TRANSPORTATION MEMORANDUM

Sunflower Landscapes
El Paso County, Colorado
PCD File No. VA265

June 2026
Revised August 2026

SM ROCHA, LLC

Sight Distance Exhibit

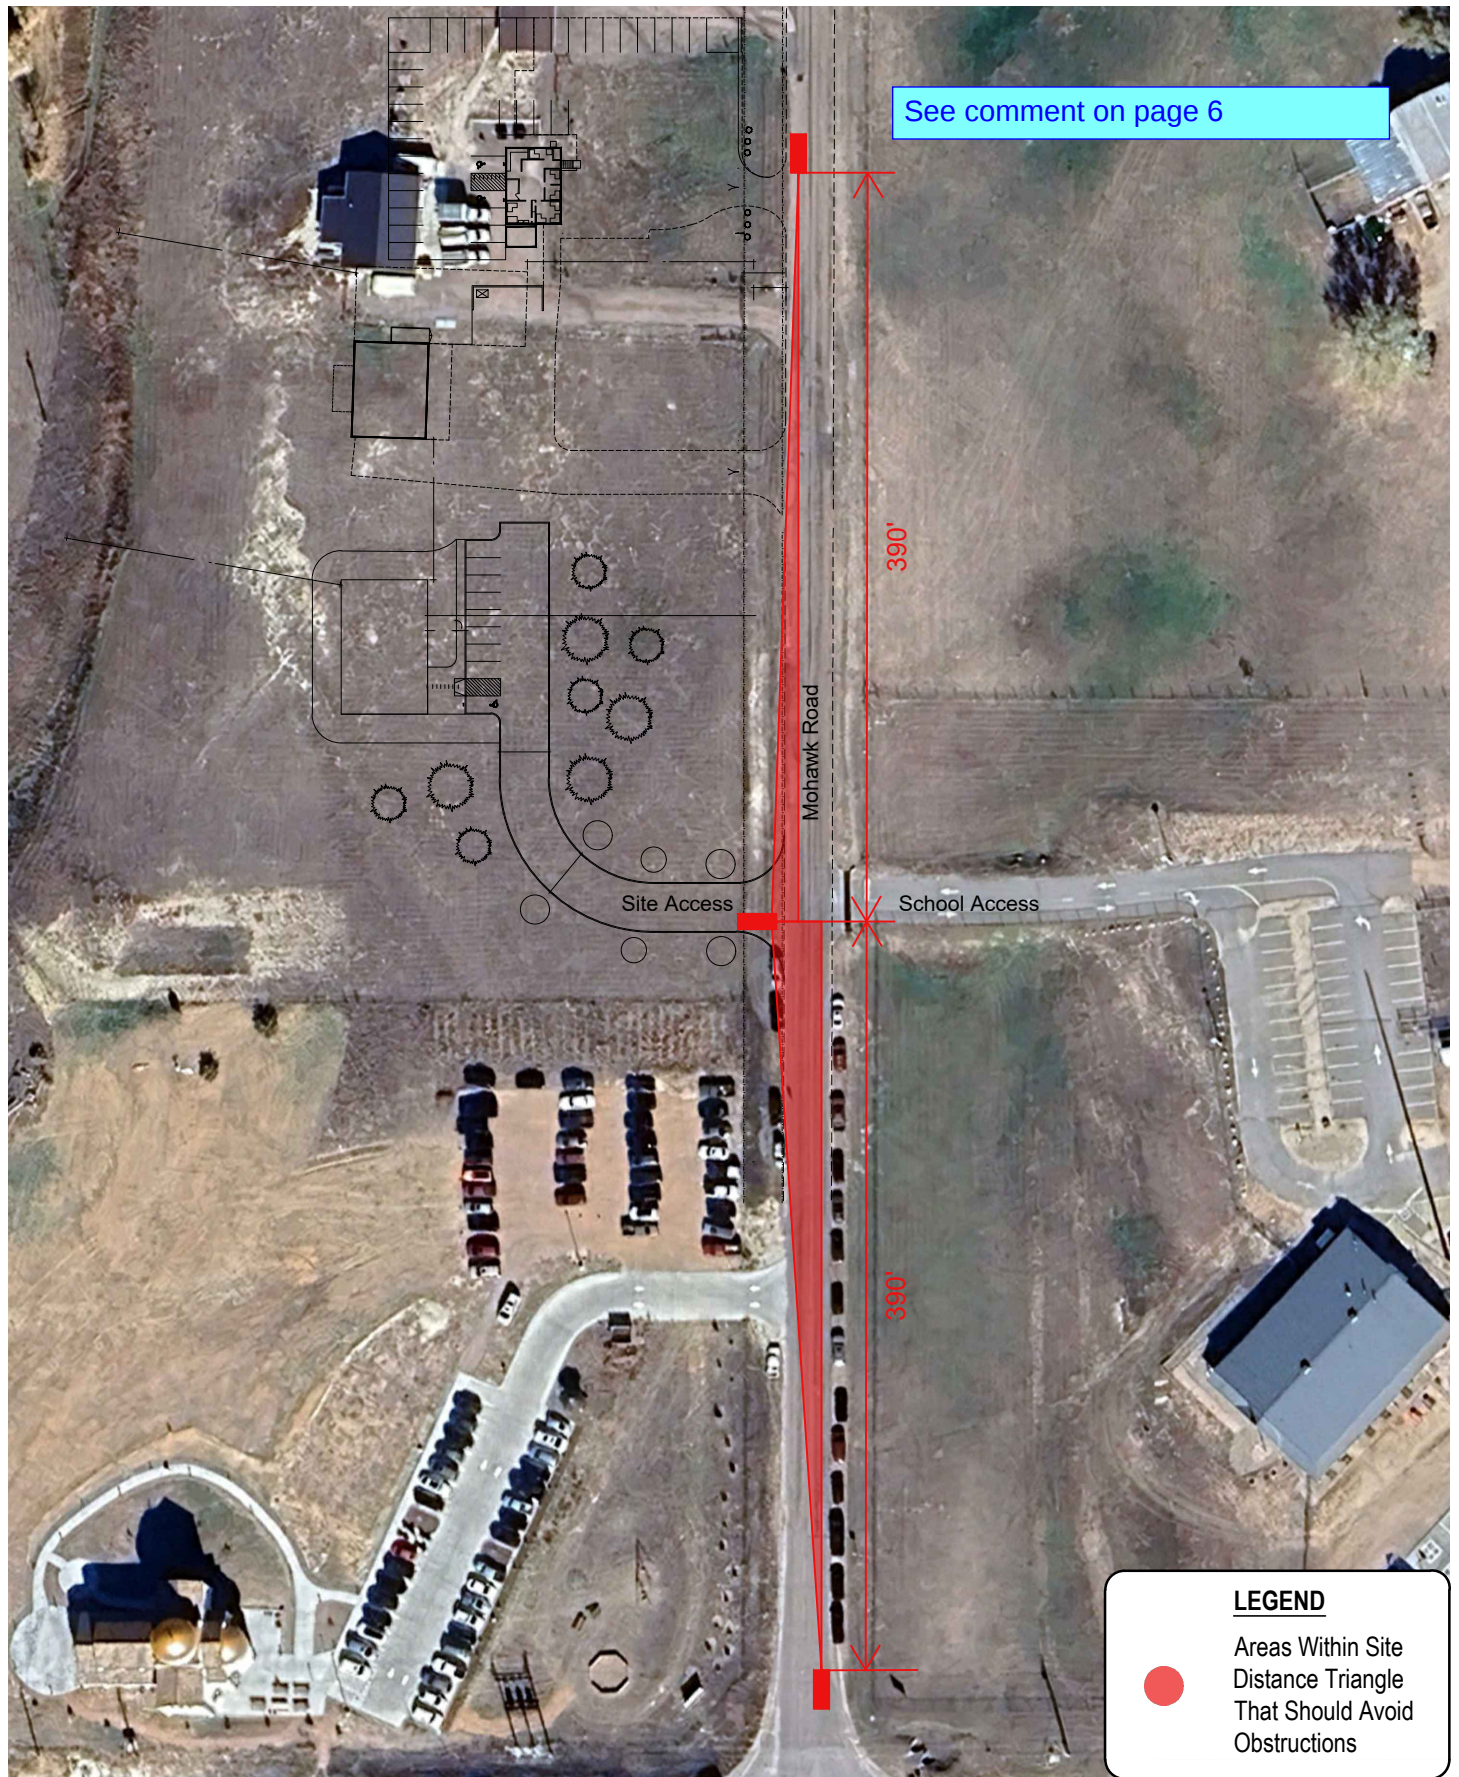
A two-dimensional exhibit does not accurately reflect whether the required sight distance is met, the vertical profile must be considered. A statement must be included whether or not the sight distance is met.

The sight distance analysis may be performed at the site development plan application instead of the variance application. If the applicant is planning to postpone the sight distance analysis, please clearly state that in this report.

Please note the the sight distance analysis shall be reflective of the type of traffic utilizing the site.

Please include what was written in the comment response in the report.
